**Transport
for NSW**

Notice of Exhibition – Locomotion Workshops (Bays 5-13 and 15), Australian Technology Park, Eveleigh (SSD 8449)

TfNSW has reviewed the submitted information and provides the following comments on the development application.

Figure 9 Locomotive Street

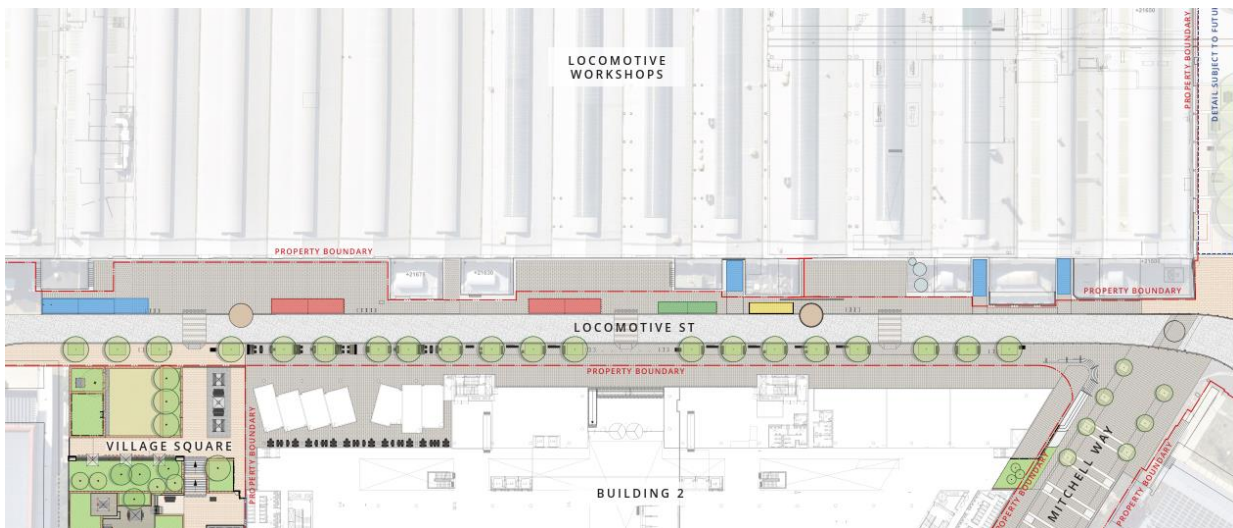
Locomotive Street is proposed to be upgraded as part of the public domain works under State Significant Development (SSD) 7317. TfNSW requests that the proponent continue to work with TfNSW to resolve the design for Locomotive Street, in particular the provision for coaches. Any works that occur in Locomotive Street as part of this application should not occur until the design of Locomotive Street is resolved.
